Project Title: NM Beef Jerky Restaurant Building Permit #: _____ Hydrology File #: J140185
DRB#: _____ EPC#: _____ Work Order#: _____
Legal Description: Lot 4 Block 21 Albright i Moore Addn
City Address: 1425 4th St. NW ABQ NM 87102

Re: NM Beef Jerky Restaurant
1425 4th St. NW
Traffic Circulation Layout
Engineer's/Architect's Stamp 07-28-17 (J14-D185)

SHEET
TCL
1 of 1
8-21-17
DATE
PROJECT NO.

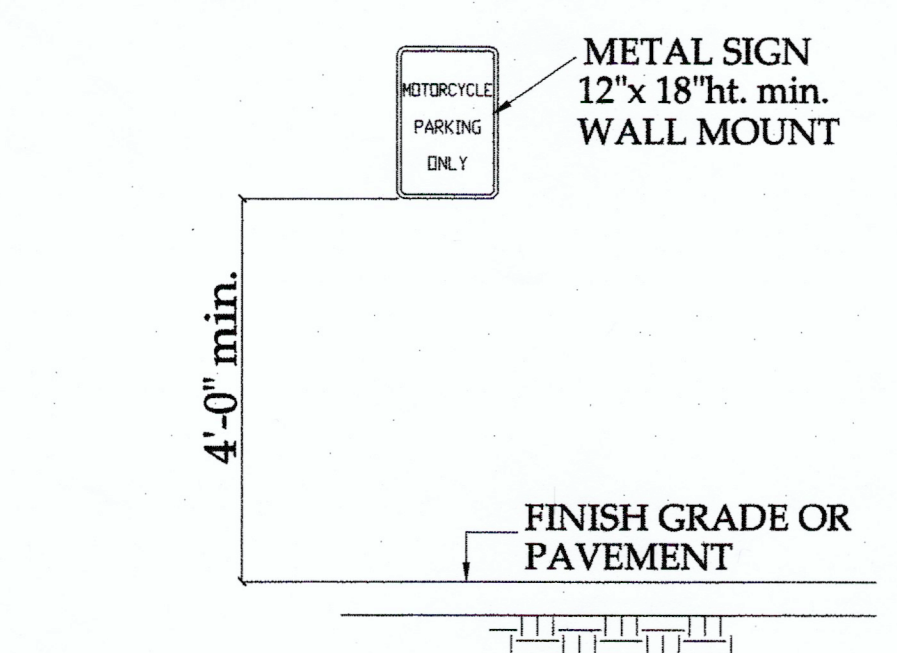
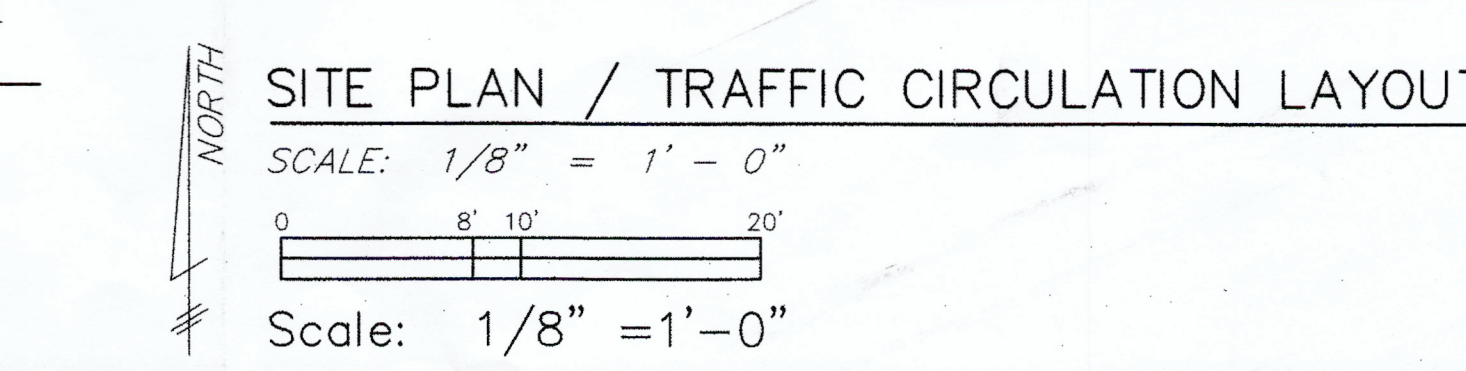
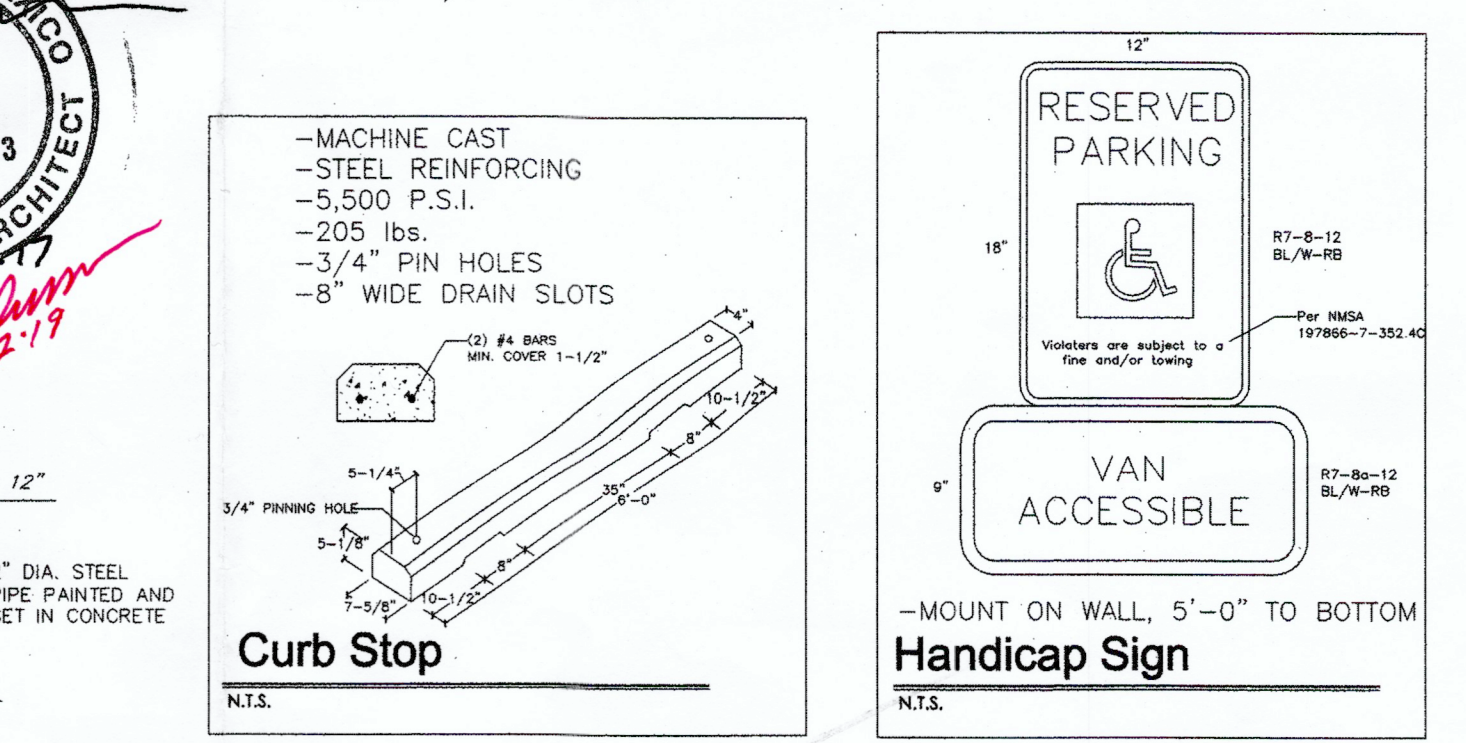
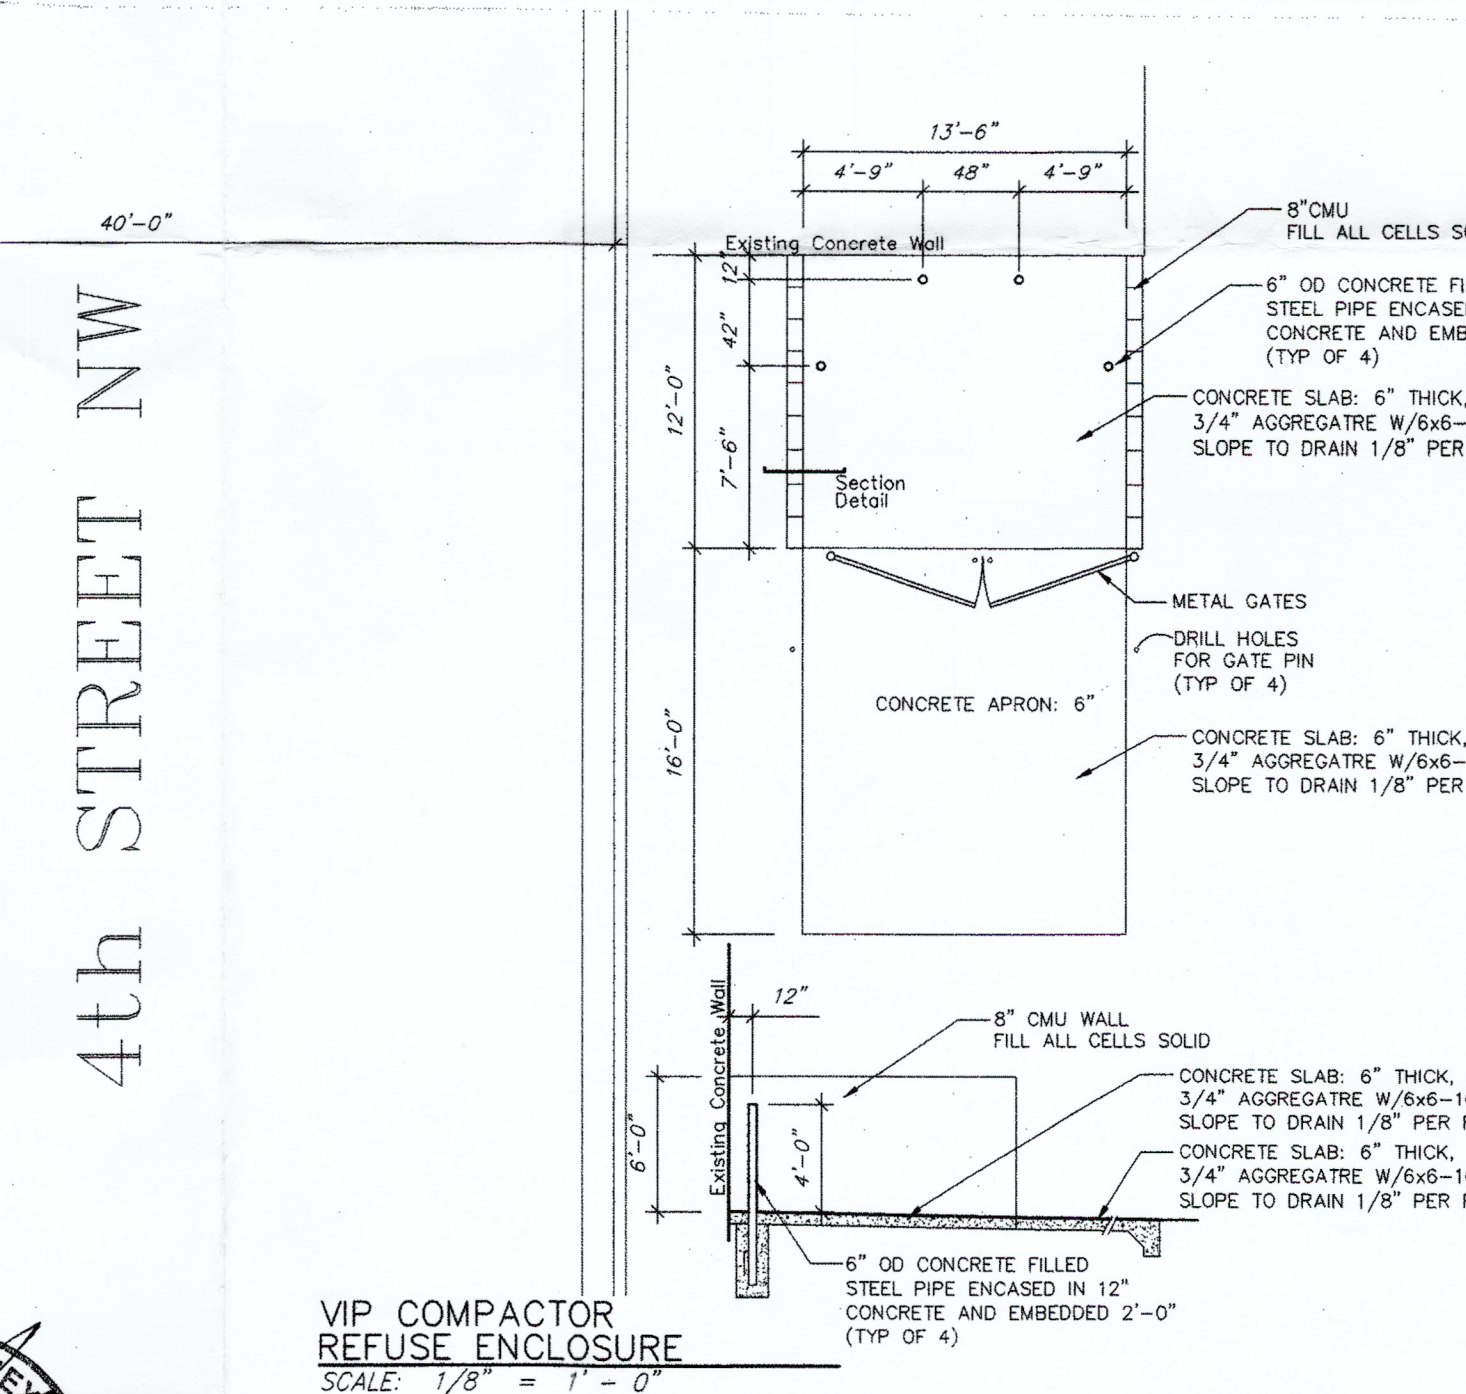
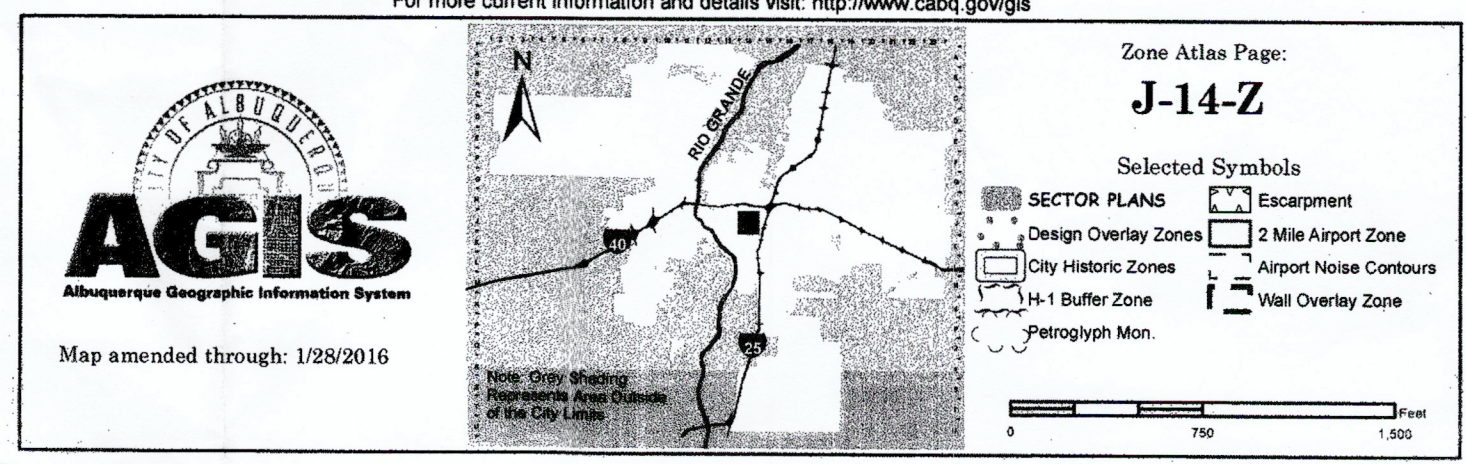
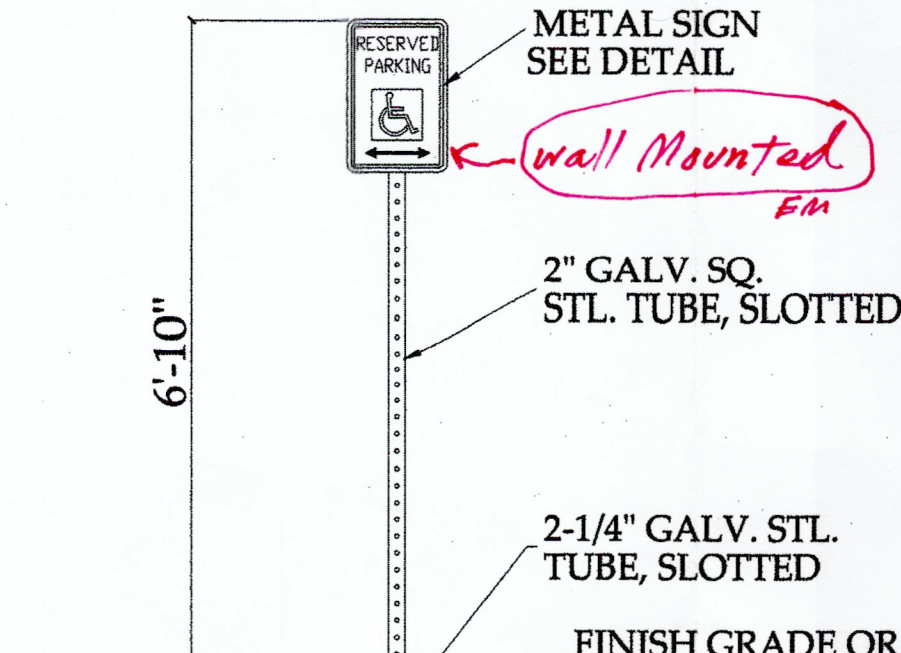
1. The scale must be shown on the plan. Per the Development Process Manual, Chapter 27, Section 2, Part B.1, on the following scales may be used:

2. Identify the right of way width, medians, curb cuts, and street widths on Constitution Ave and 4th St.
3. Clarify existing property lines and proposed property lines.

4. Indicate if the new entrance will be flush with asphalt or provide ADA ramp.
5. It is not clear what the parking lot surface will be. Please provide the type of surface treatment.

6. Please list the width and length for all existing and proposed parking spaces. Some dimensions are not shown. The access aisle should be 24 feet for two way traffic. (may want to look at the lengths of the parking stalls they look to be over 20 feet long standard parking space can be 18 feet)

7. Provide a sign indicating the motorcycle parking.
8. Parking spaces cannot cross over lot lines. Parking spots must be inside the property line.
9. When accessing 4 or more parking spaces off the alley or use for refuse the alley must be paved per the zoning code. § 14-16-3-1 Off-Street Parking Regulations.

11. Please add a note on the plan stating "All improvements located in the Right of Way must be included on the work order."
